MDDP and

FINAL DRAINAGE REPORT

MERIDIAN ROAD & BENT GRASS MEADOWS DRIVE

El Paso County, Colorado

MERIDIAN ROAD DRAINAGE PLAN

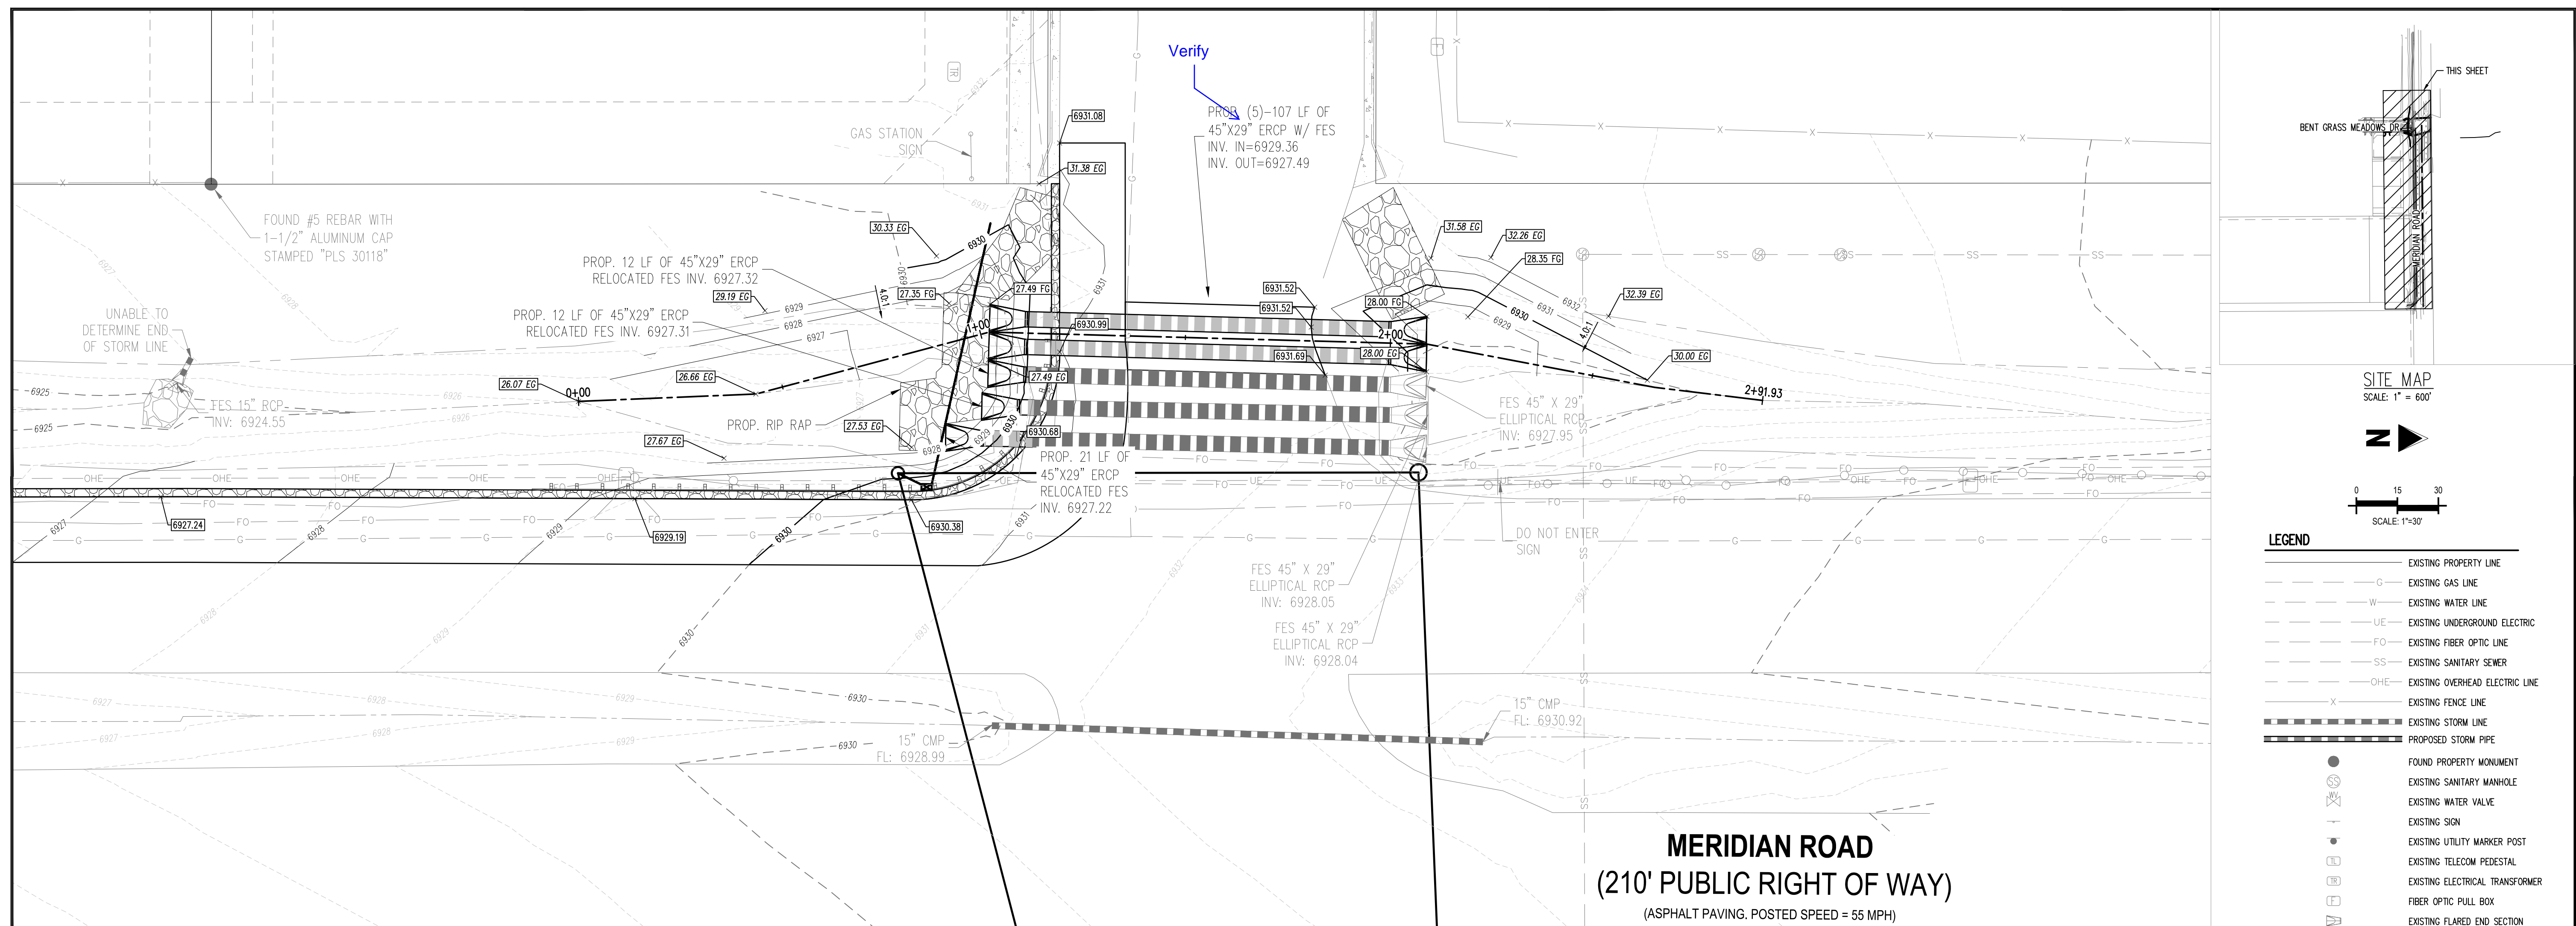
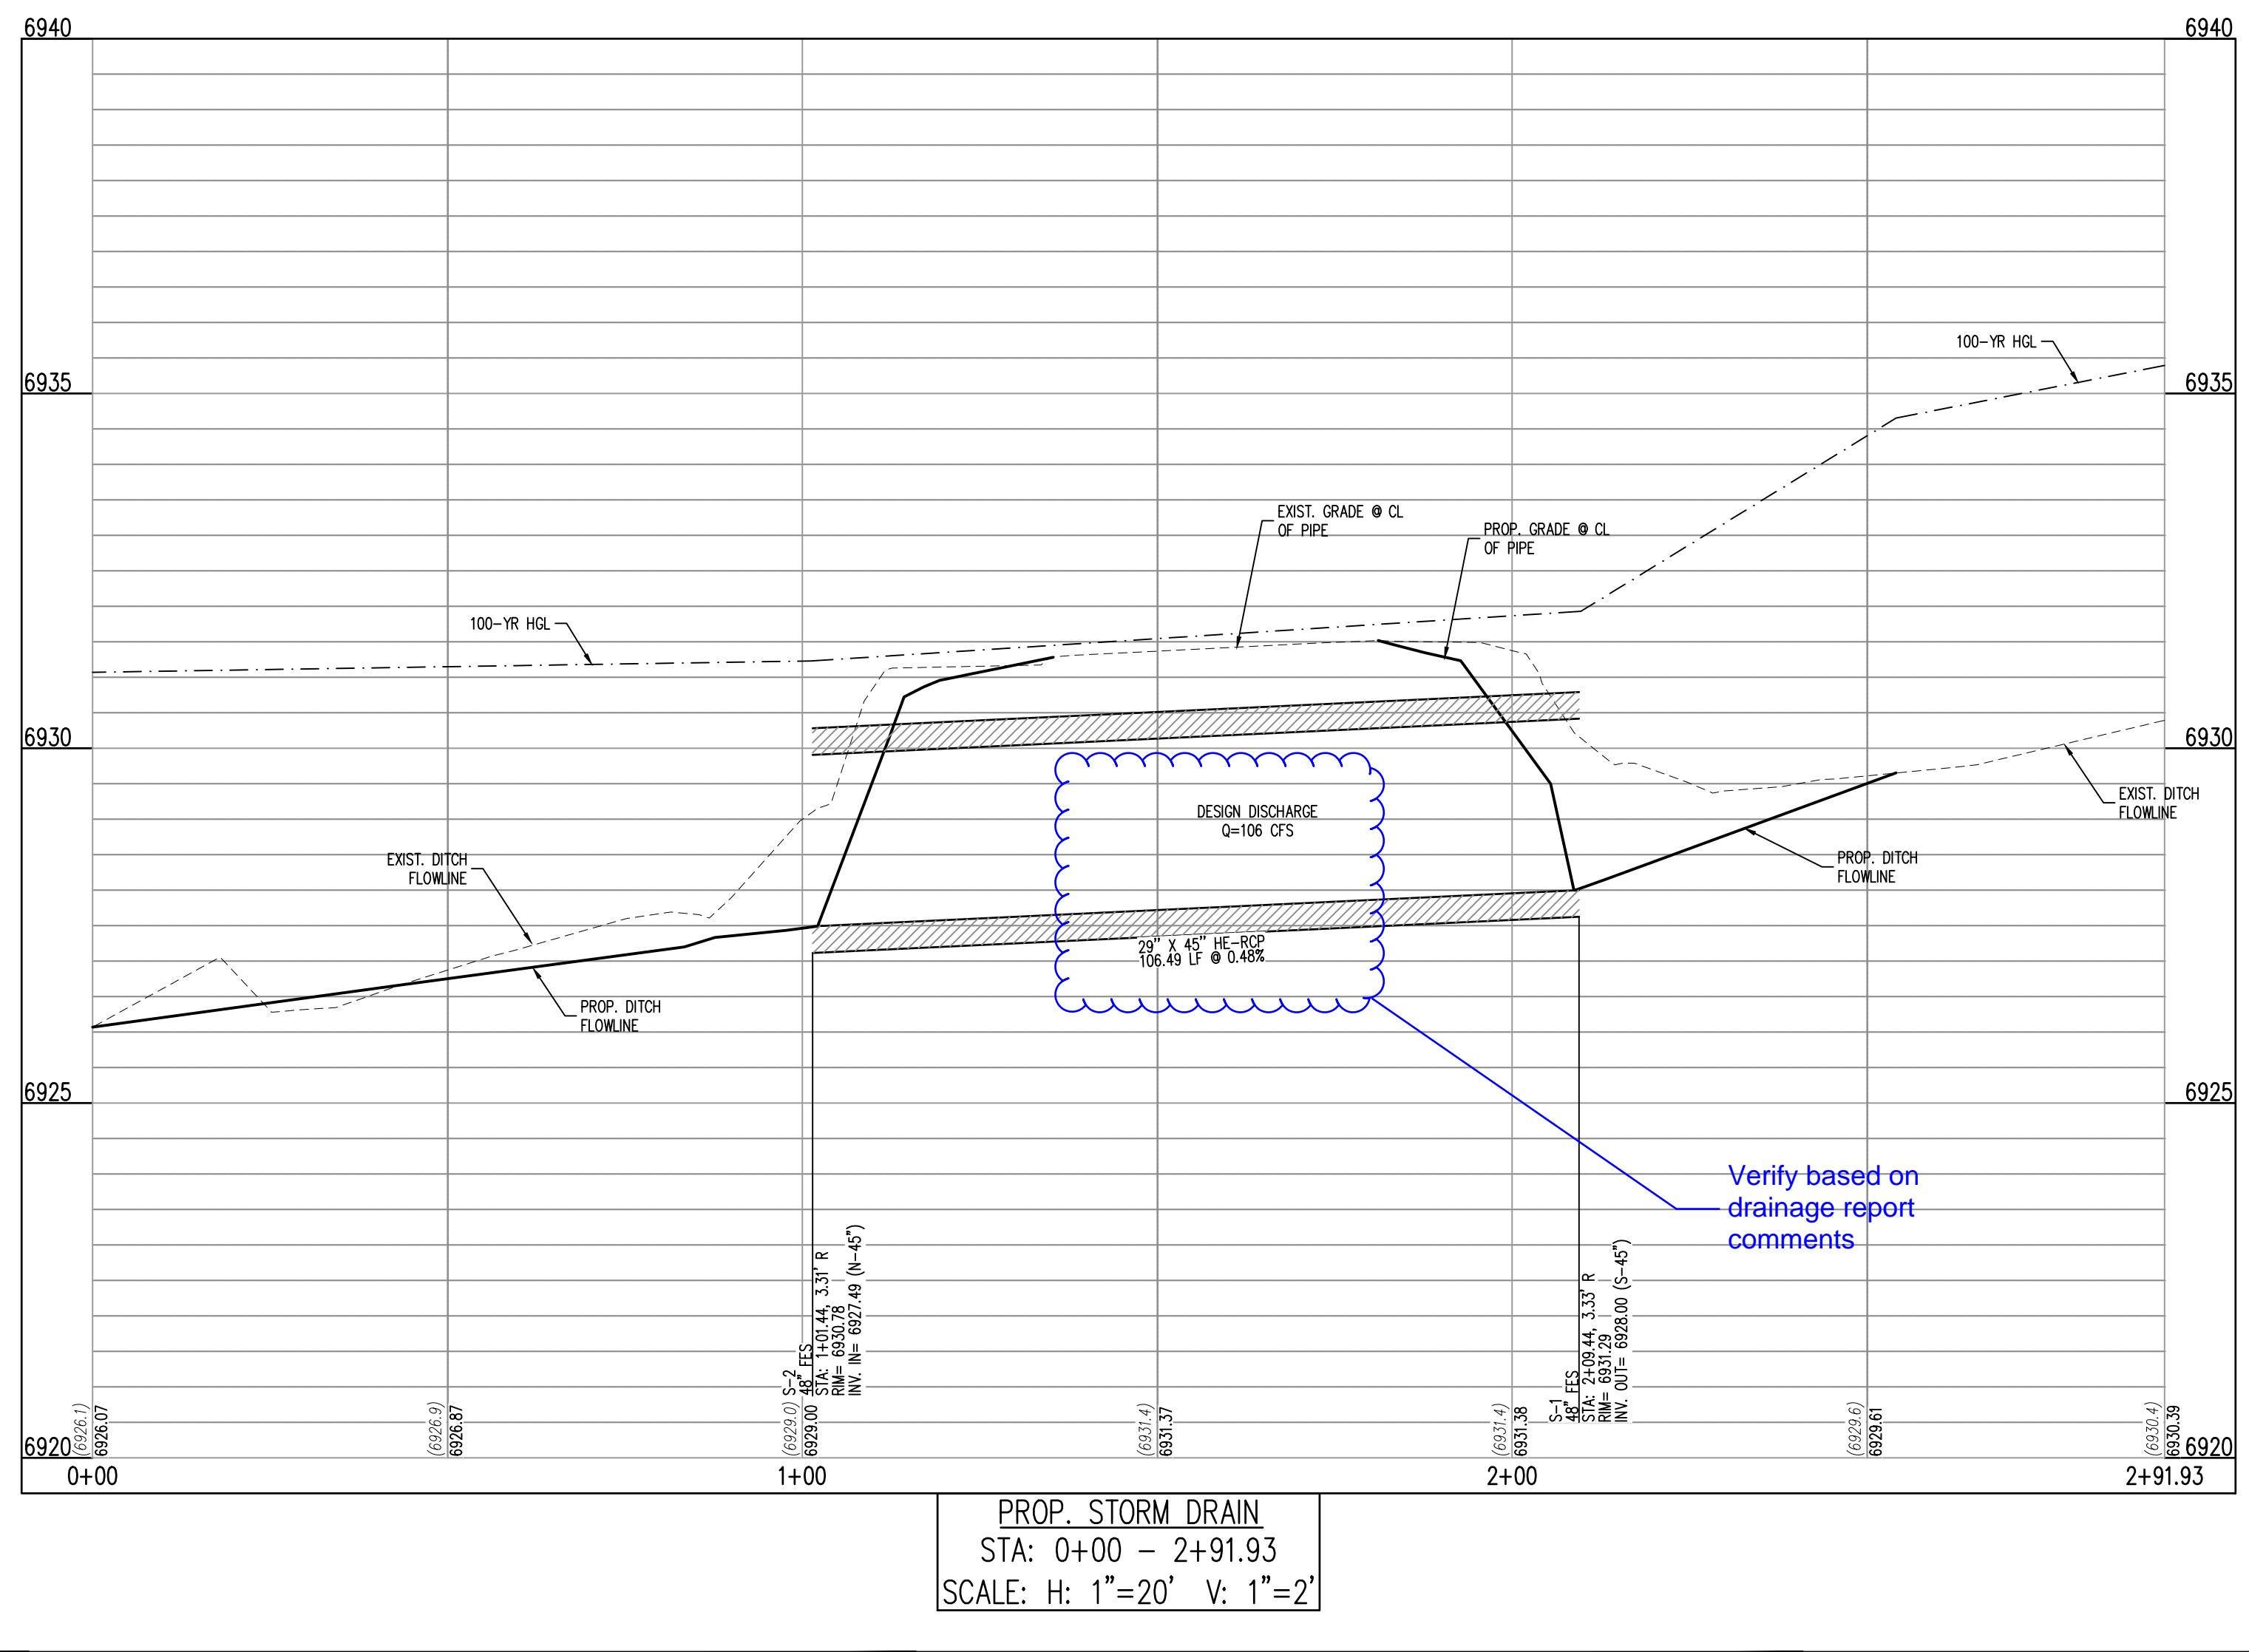
The Bent Grass development has routed more flow to the road; what improvements are necessary to stabilize the roadside channel?

← Address the interim condition with the added flows.
Is interim protection proposed?
